Application no: **3/2021/1054**

Address: **23 Whalley Road Wilpshire BB1 9LQ**

Proposal: **Proposed change of use and exterior alterations of a former photography studio (Use Class E) to three flats (Use class C3) and associated infrastructure.**

The Local Highway Authority have viewed the plans and highway related documents and have the following comments to make:

PROPOSED BLOCK SITE PLAN
1:200@A3

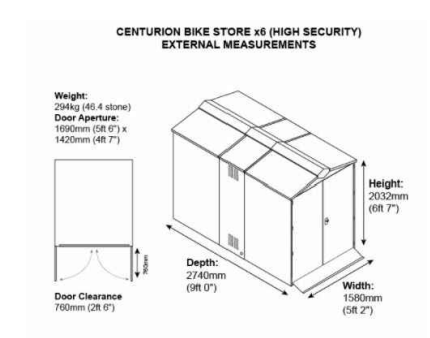
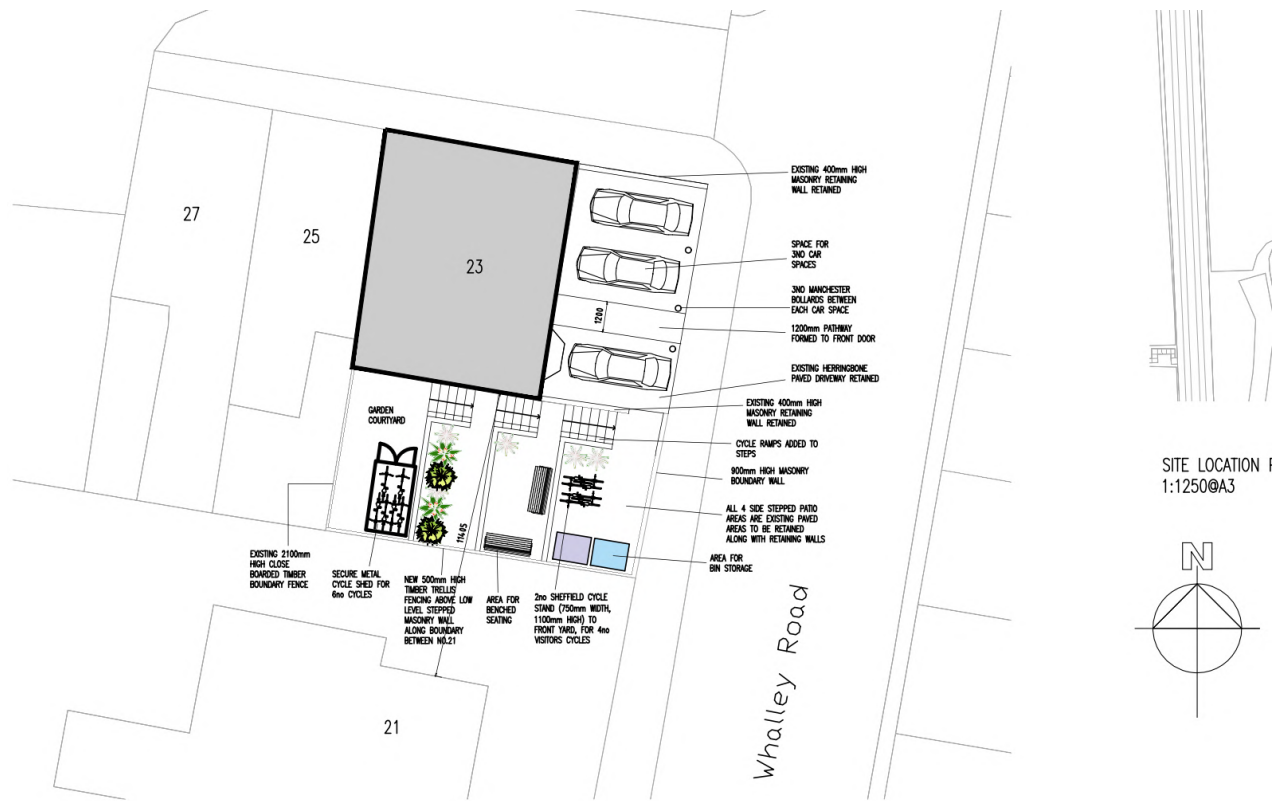
The LHA have reviewed Mark Gordon drawing number 23WR/200/PL Rev P2 titled "Site Location Plan, Proposed Site Plan" and understands that the site will provide 3 car parking spaces for the 3x 2 bed flats.

However, the LHA have reviewed the dimensions of the spaces and are unable to accept the space closest to the existing shop window, as shown on the drawing. This is because the car parking space is only approximately 4.4m in length, while the LHAs guidance states the minimum length of a space is required to be 4.8m. Therefore, the LHA are unable to accept the parking space and so the site can only provide 2 car parking spaces.

The parking arrangements, as result, do not comply with the parking guidance found in the Joint Lancashire Structure Plan which requires 2 bed flats to provide 2 car parking spaces each. Therefore, there is a shortfall in 4 spaces.

However, should a revised parking plan be submitted which shows the parking space closest to the window to be removed, the LHA will accept the shortfall in car parking at the site.

Therefore, with these factors in mind and there being on-street car parking available with it being a pre-existing situation adjacent to the building, following the removal of the car parking space shown on a revised plan, the LHA will have no objection to the proposal.
